**Re: Luxelocker Albuquerque at 5601 San Diego Ave NE
Erosion and Sediment Control Plan
Engineer's Stamp Date 5/10/23 (B18E031)**

Based upon the information provided in your submittal received 5/10/23, the above-referenced ESC Plan cannot be approved for Building Permit until the following additional information is provided.

Chancellor English
Erosion and Sediment Control Specialist, Planning Dept.
Development and Review Services

Sheet Number:
C1
1 of 4

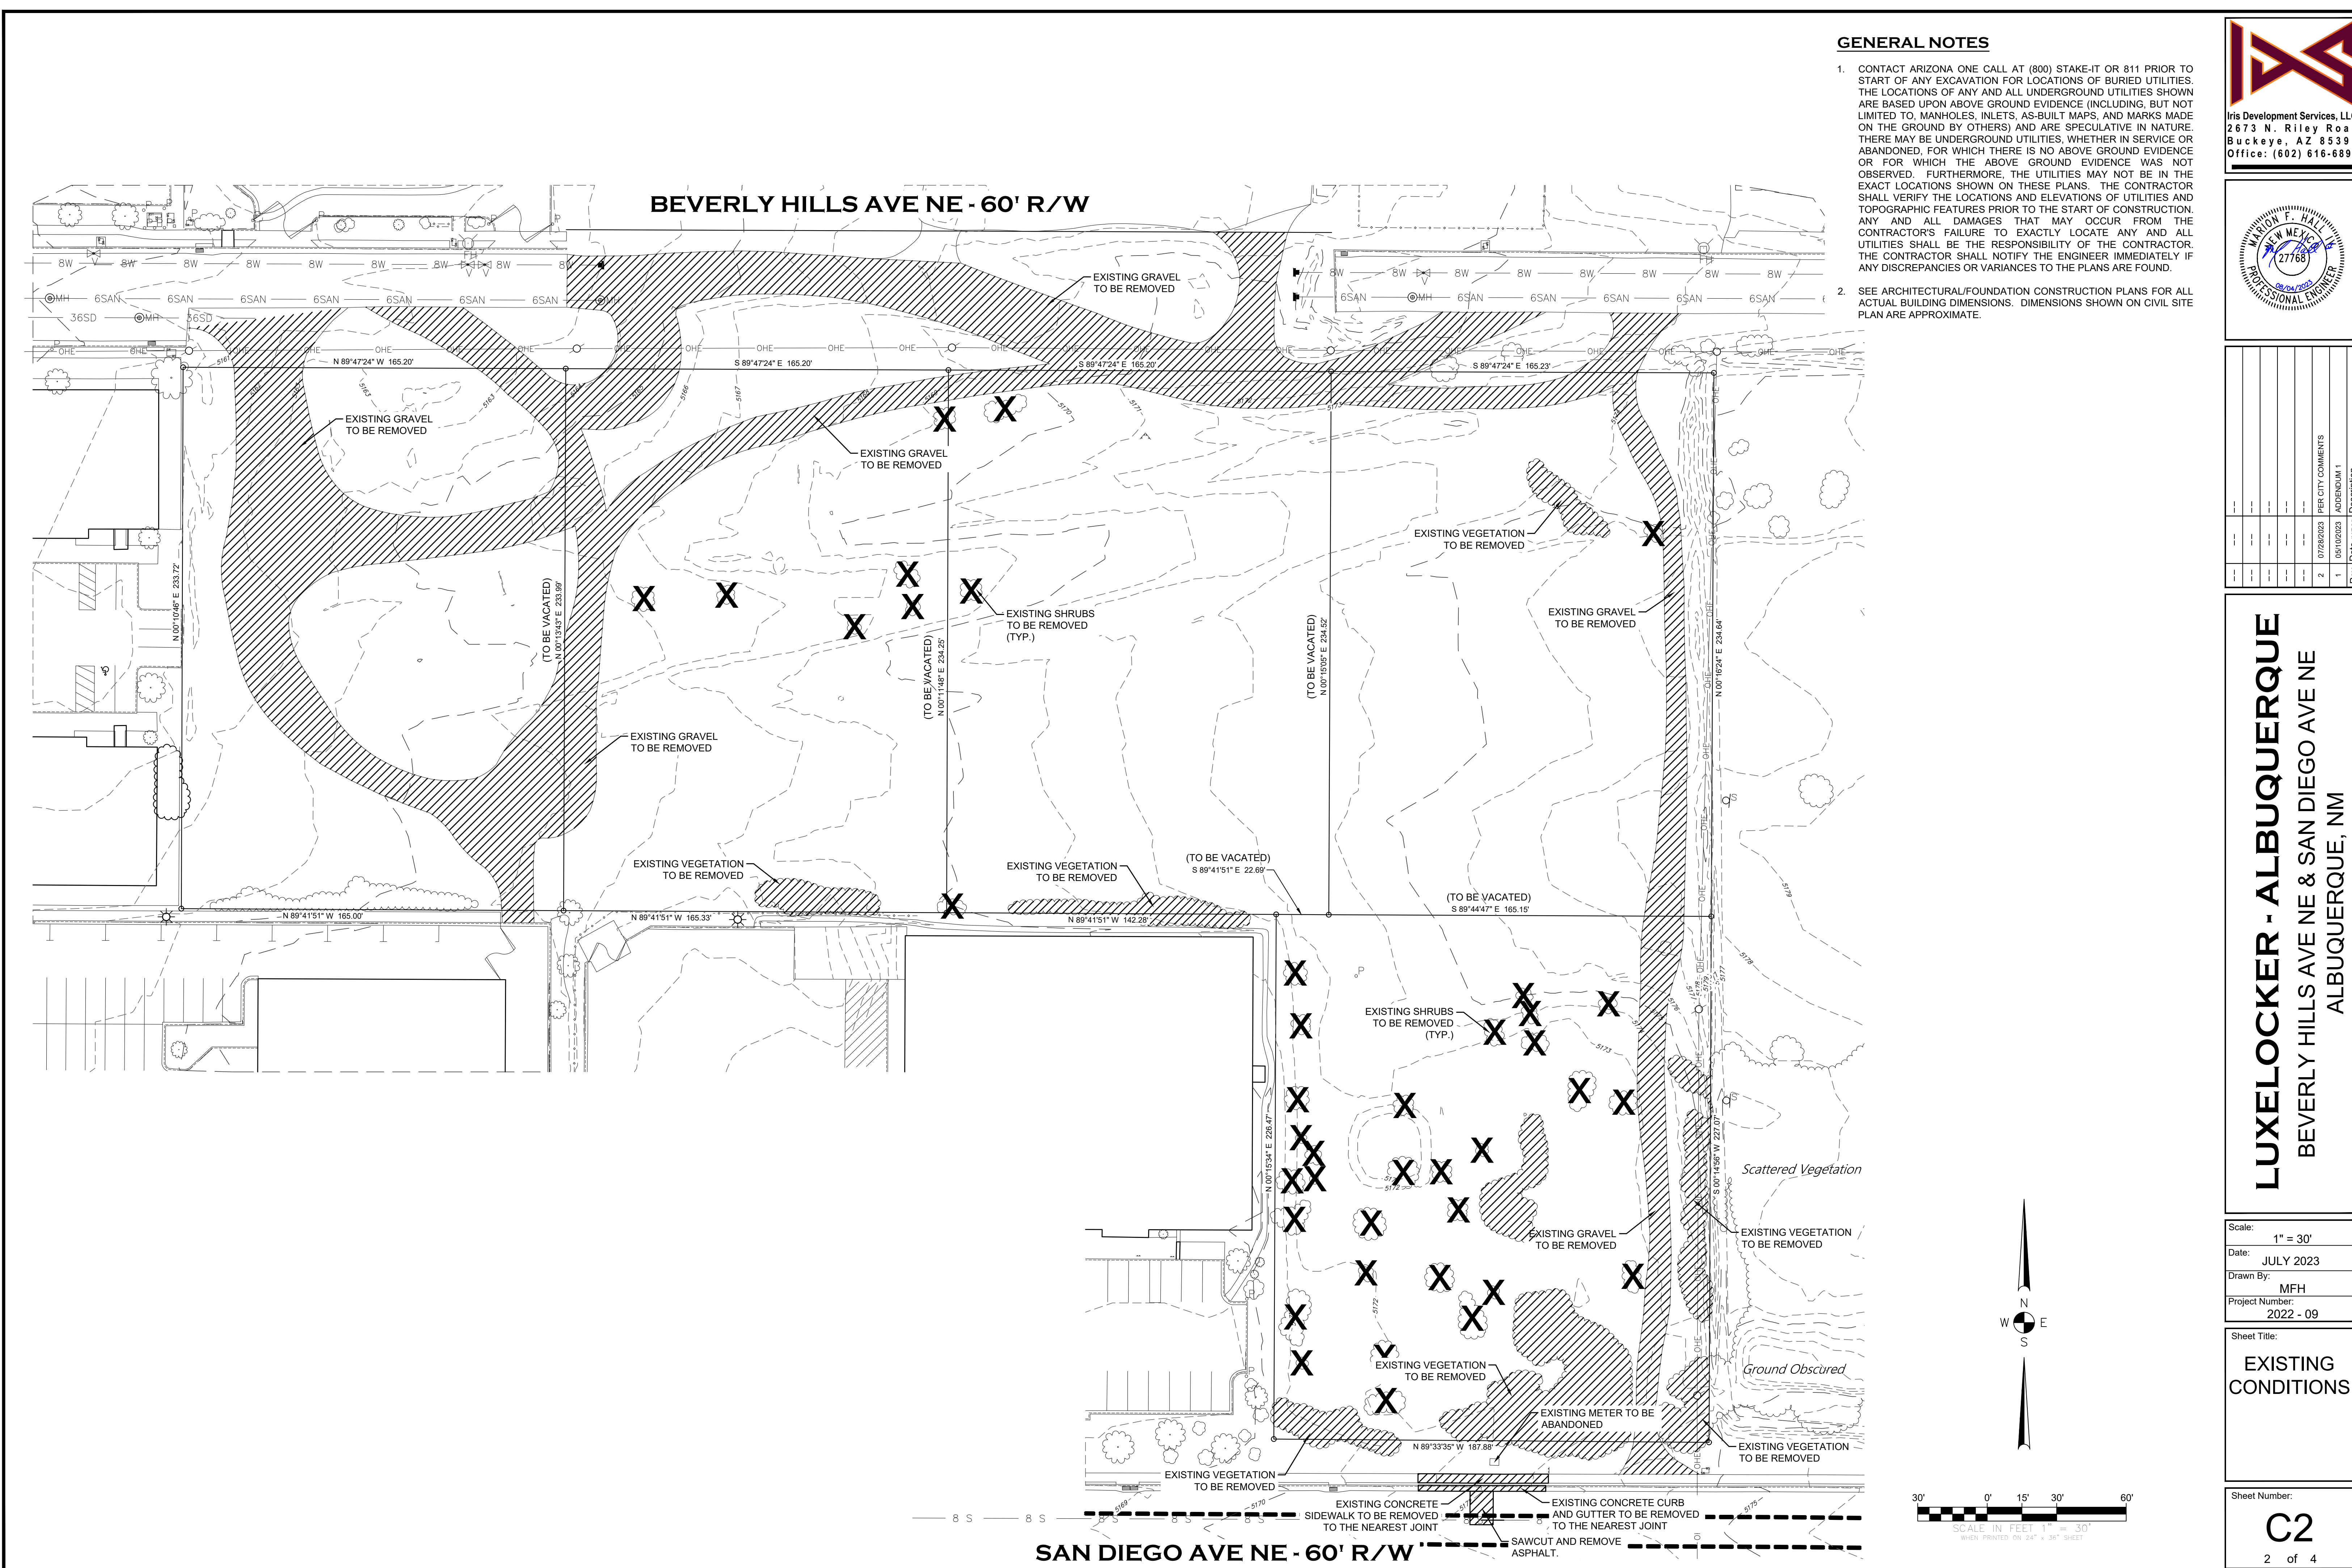
1. The General Notes and Construction Notes should be amended to add the City's ESC Plan Standard Notes, which can be found on the City of Albuquerque's website: www.cabq.gov/planning/development-review-services/stormwater-quality-section.

2. Vicinity map – add a zone atlas map clearly indicating location and street names.
3. The perimeter controls listed in the SWPPP and on the ESC Plan do not match. Amend the ESC Plan map to installation of silt fencing around the perimeter, as straw wattles are not sufficient for perimeter control.

2
C4
SEDIMENT TRAP DETAIL
SCALE: NONE

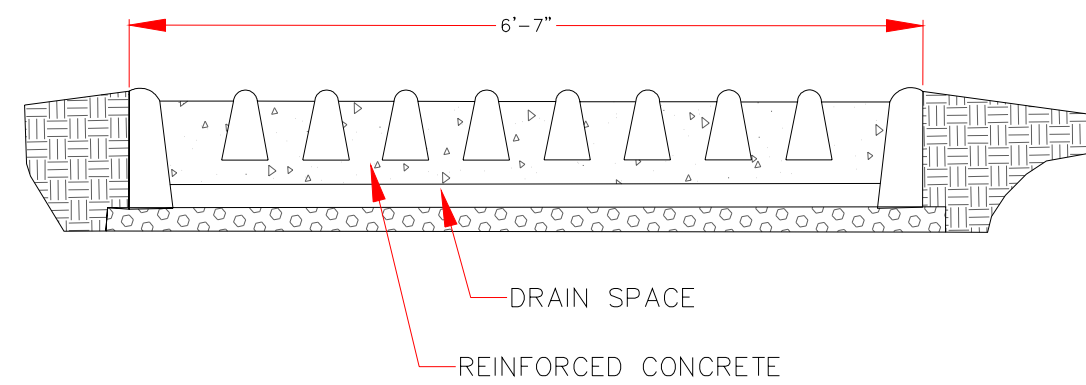
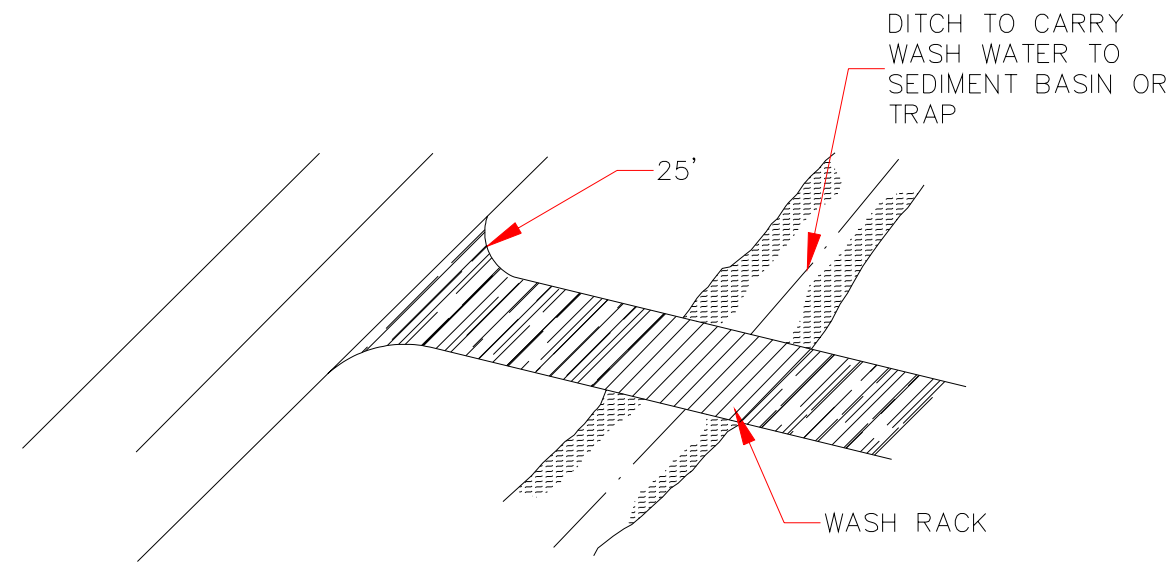
4. Design Sediment Traps and/or Sediment Basins in accordance with CGP 2.2.12 and provide calculations. Take note that the sizing requirements differ for ponds used as BMPs during construction and the final design.
